Your Ref: OWPC3656
Our Ref: LU/223/14/PL
Please ask for:
Simon Davis

4th September 2014

Application under Regulation 3 of the Town and Country Planning General Regulations 1992 for erection of 8No houses and associated parking, hard and soft landscaping, on an existing parking court
Land north of 52-67 Greenfields Littlehampton

Thank you for your internet comments made on 3rd September 2014 which has been recorded as **'an objection'** with the comments as follows:

DRAWING NO. J48.22/02
Scale: 1:200 at A3
Added to by: NL
03/02/2014

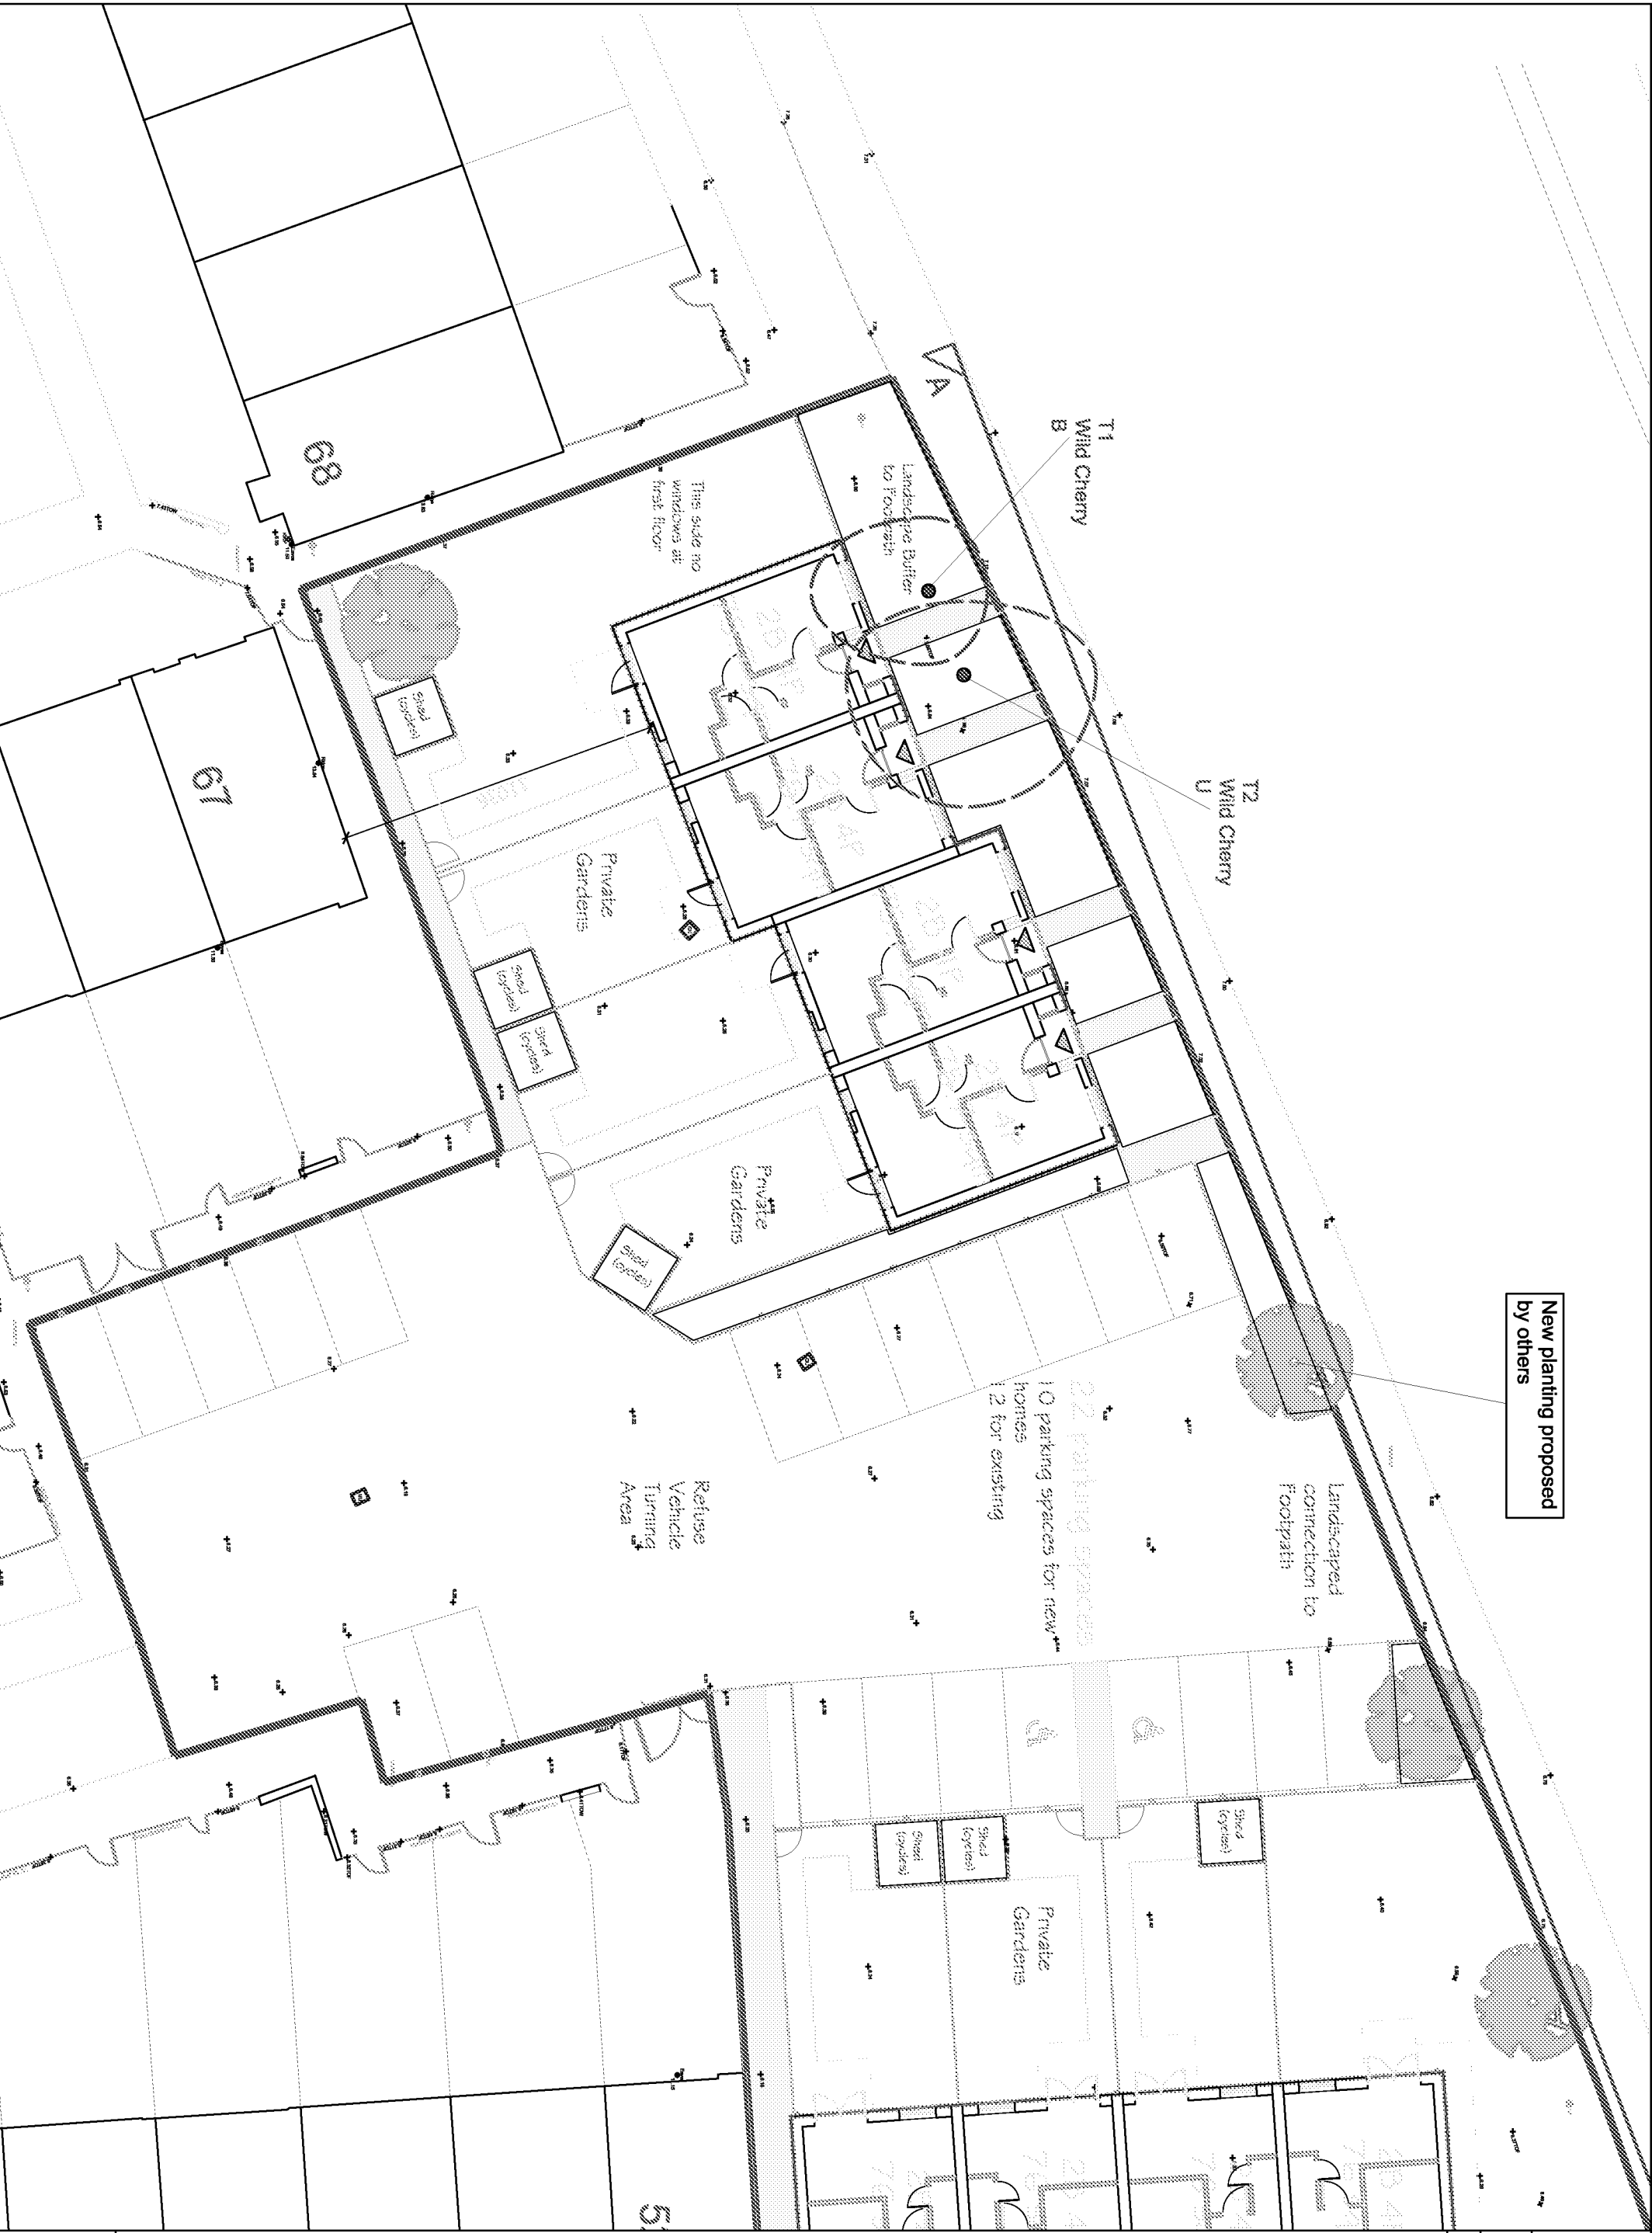
- *The estimated parking on each site are based on conclusions from one parking needs survey carried out the week before Christmas 2013 that on street parking could be reduced.*
- *No displaced parking due to development will occur based either on full current onsite capacity or observed levels (LU/223/14)*
- *New offsite parking uses the green strip/verge to edge of Greenfields (LU/227/14)*
- *The proposed new offsite parking is not as accessible to residents of existing housing as the current parking.*
- *For the new houses that are facing northwards access to parking for shopping etc. is very poor*

- Each site has been assessed separately which for a number of dwellings which do not require a formal Transport Assessment. It is unclear if the applications have been assessed collectively
- The report concludes that 'the site layout allows sufficient room for refuse and service vehicles to negotiate'. The 'swept path analysis' is very tight to the new parking bays and would block access to new housing

Figure 8: Daytime Noise Map

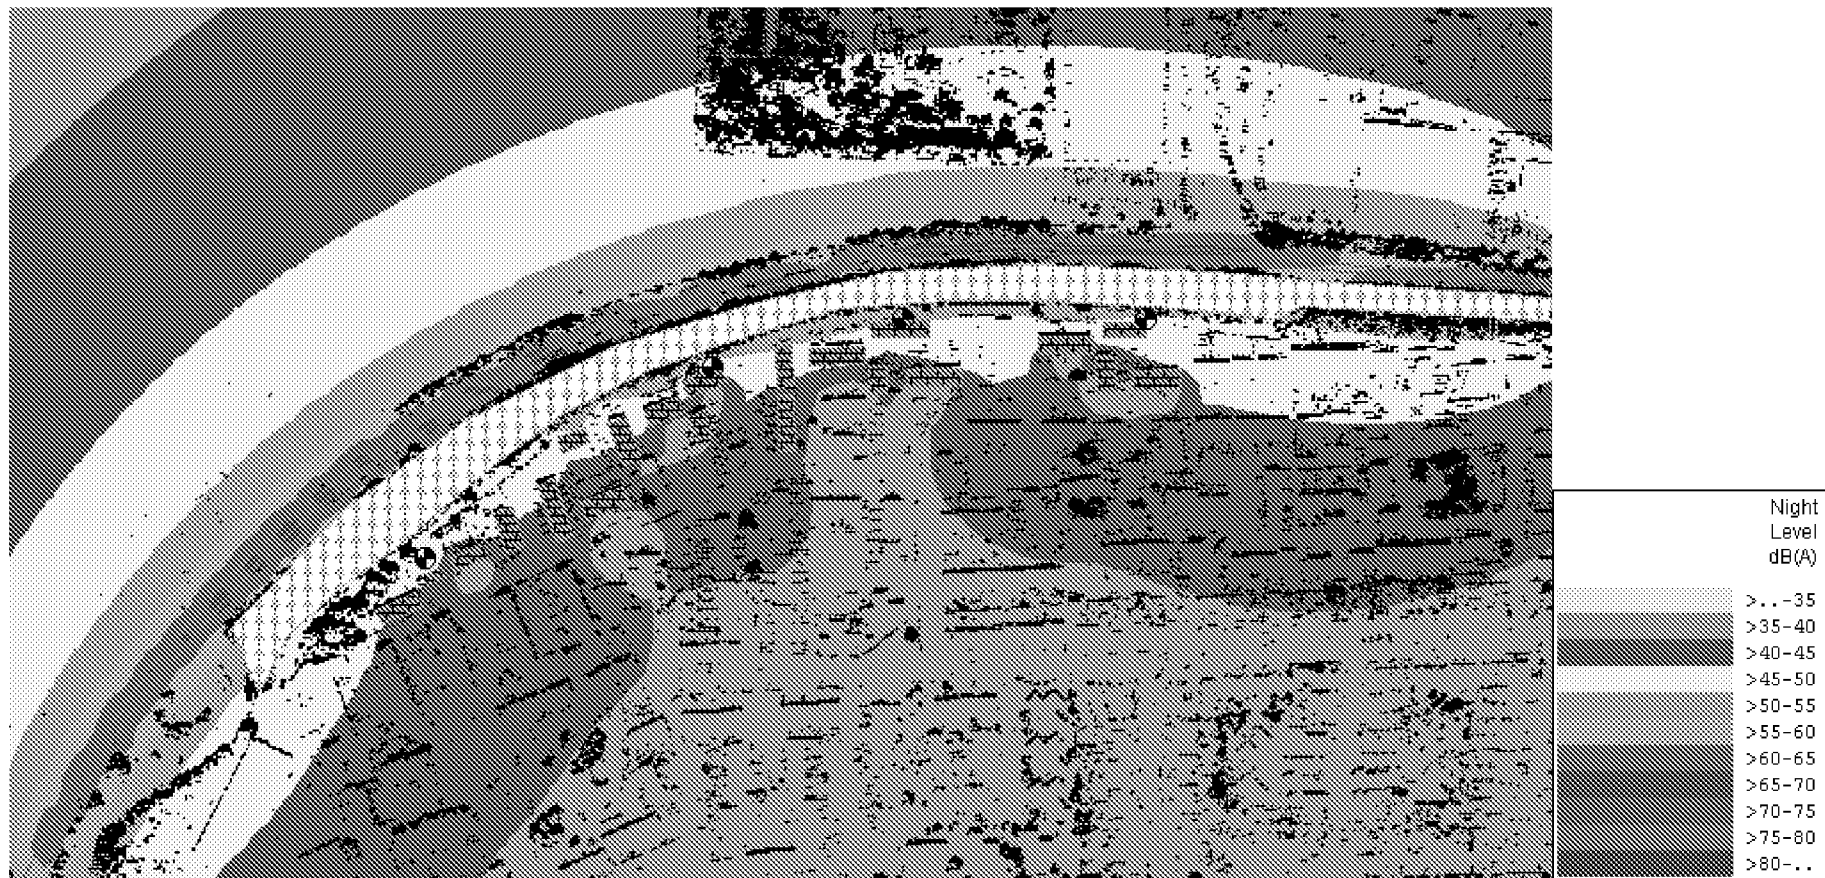
- These conclusions particularly affect houses that face towards the north and have very small front gardens
